February 17, 2012

RE: 25 Sumac Street – 378-A-21 & 22 – R-2 Zone

I am in receipt of your request for a determination letter concerning the rear, vacant described lot behind the single family developed lot located at 25 Sumac Street. Both the developed and undeveloped lots are located in an R-2 residential zone.

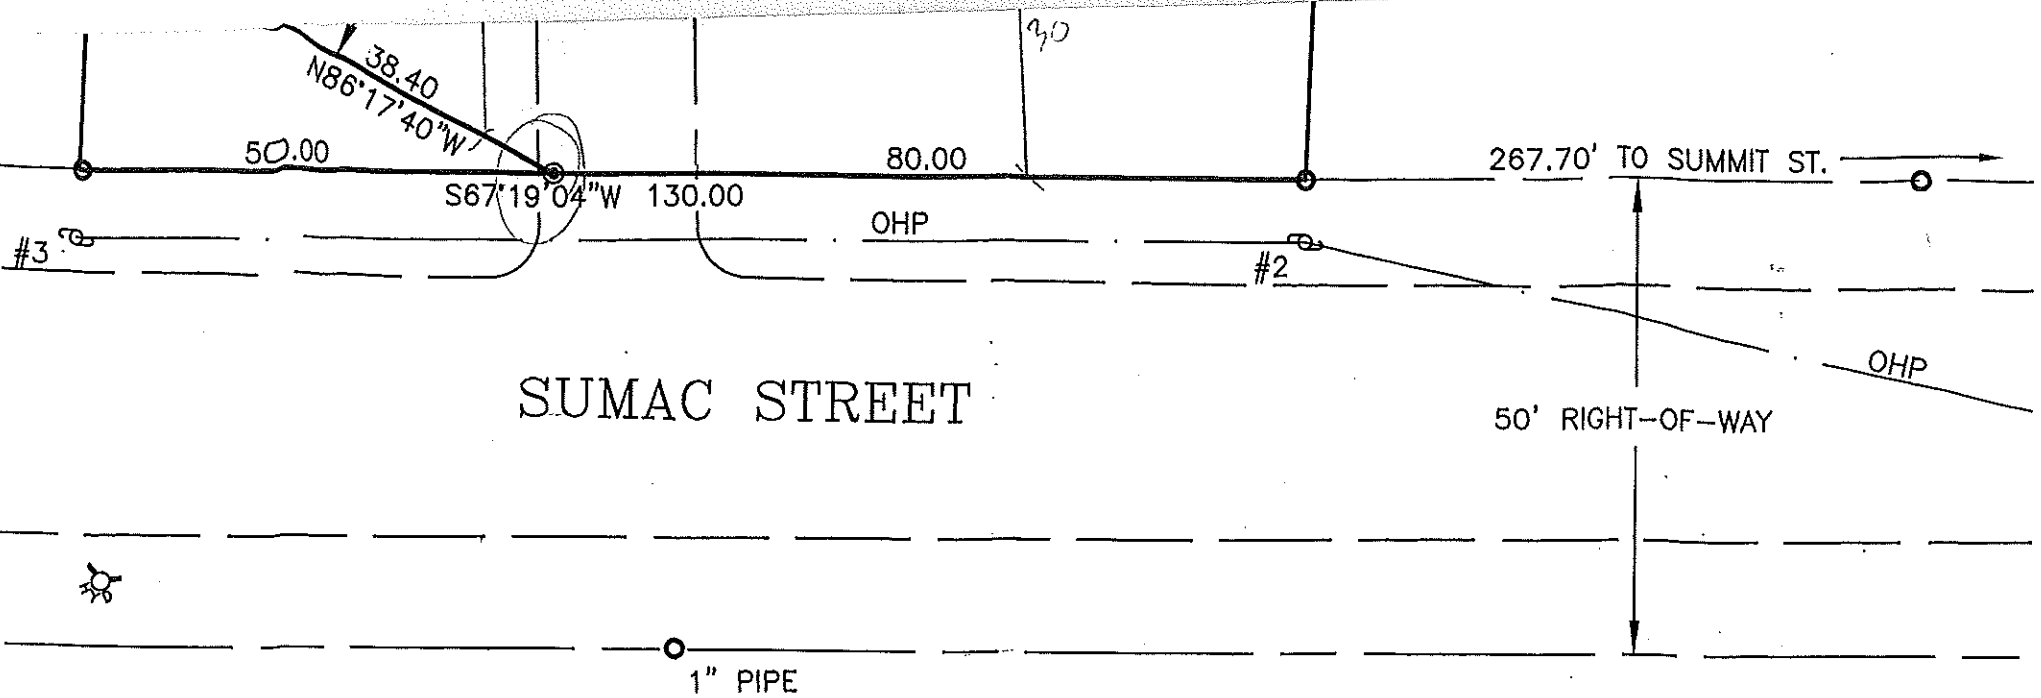
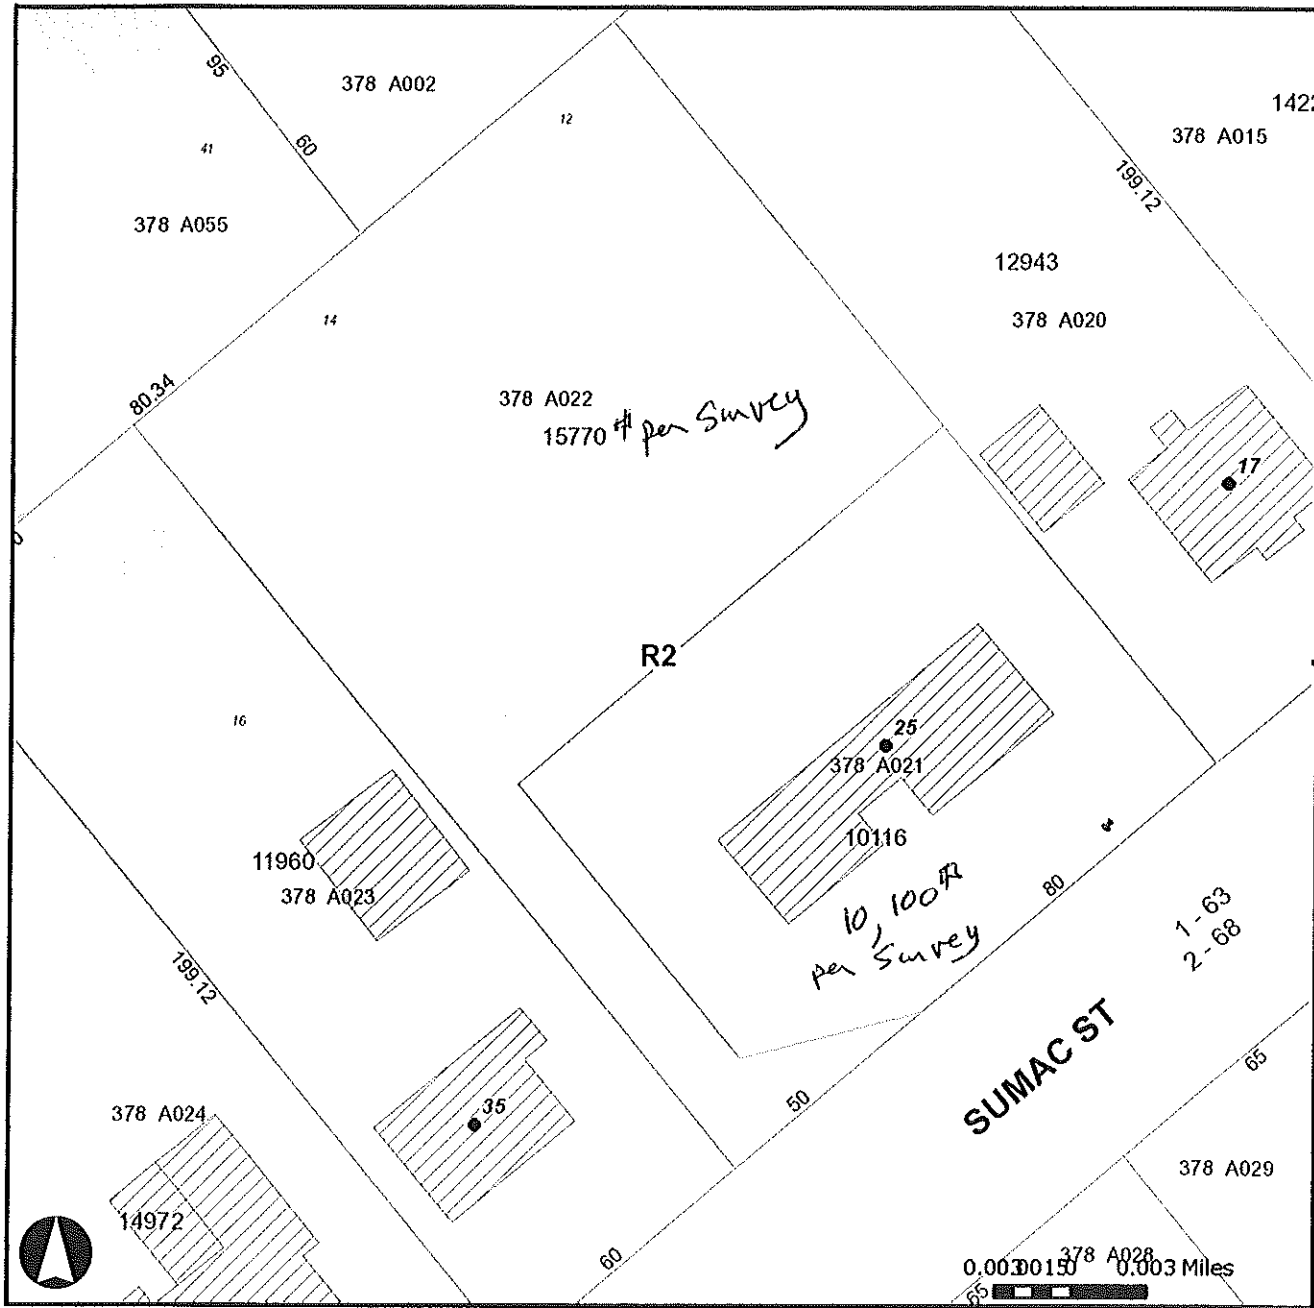
It is noted that there is an encroachment of the driveway for 25 Sumac Street onto the newly proposed lot at the street line. It is recommended that prior to the finalization of the lot split by conveyance, that an easement be prepared for the driveway encroachment.
